Your Ref: OWPC15538
Our Ref: AL/83/17/PL 17-07-2017
Please ask for:
Michael Eastham

Demolition of existing dwelling & erection of 1 No. dwelling.
Mildmay Hook Lane Aldingbourne

PROPOSED REAR ELEVATION

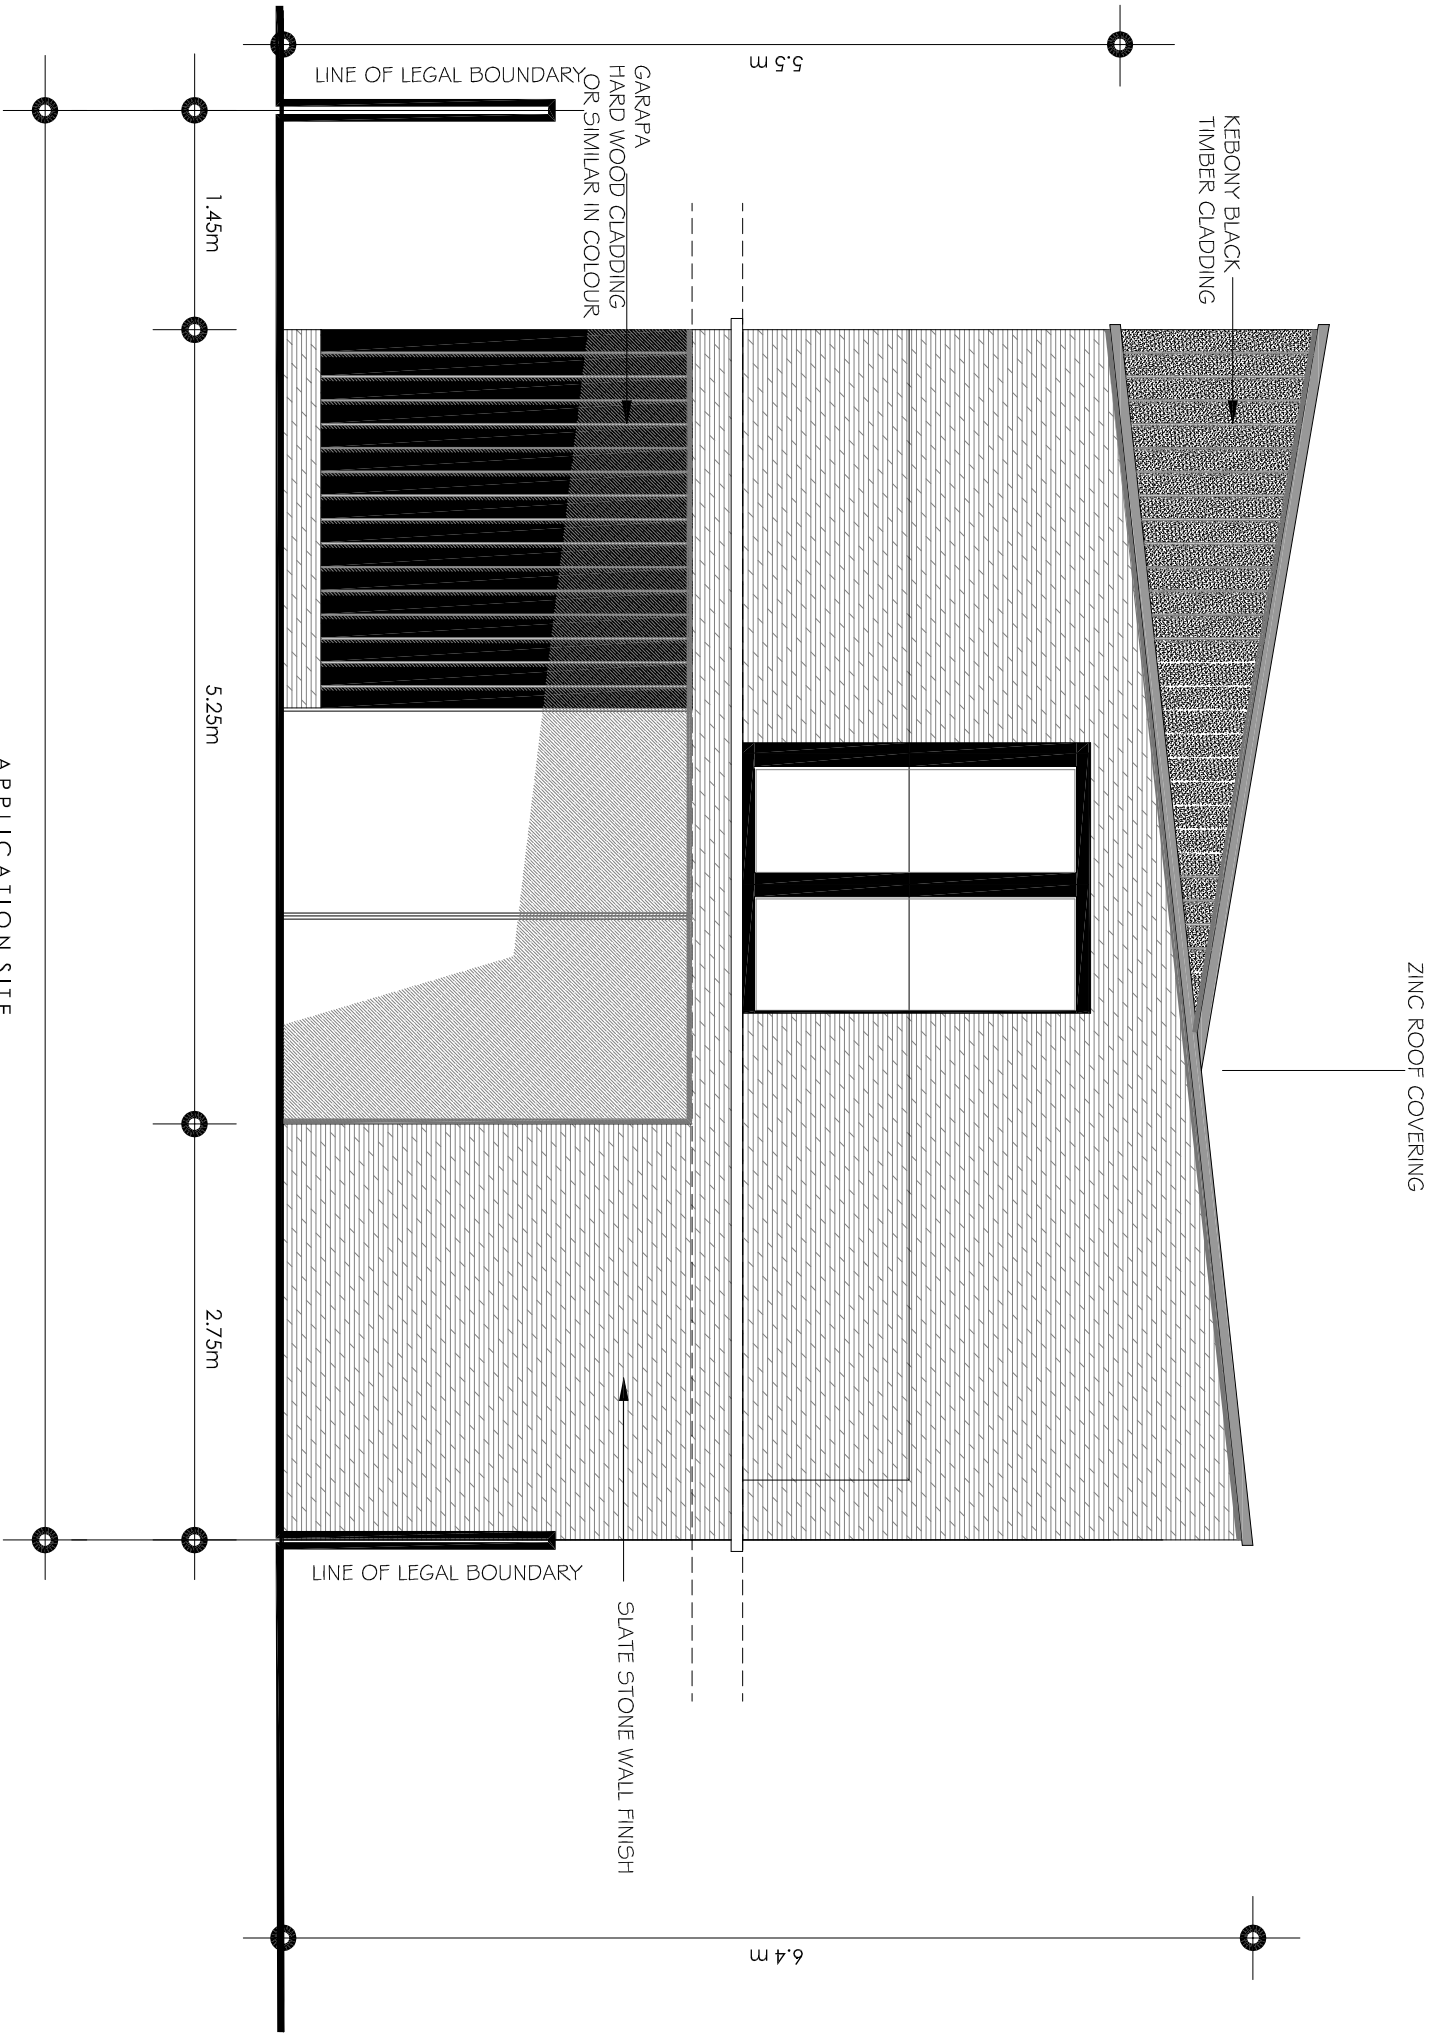
My only concern is the first floor rear balcony being angled towards our garden which would affect privacy. If the balcony was in line with the back of the house and not angled I wouldn't see an issue
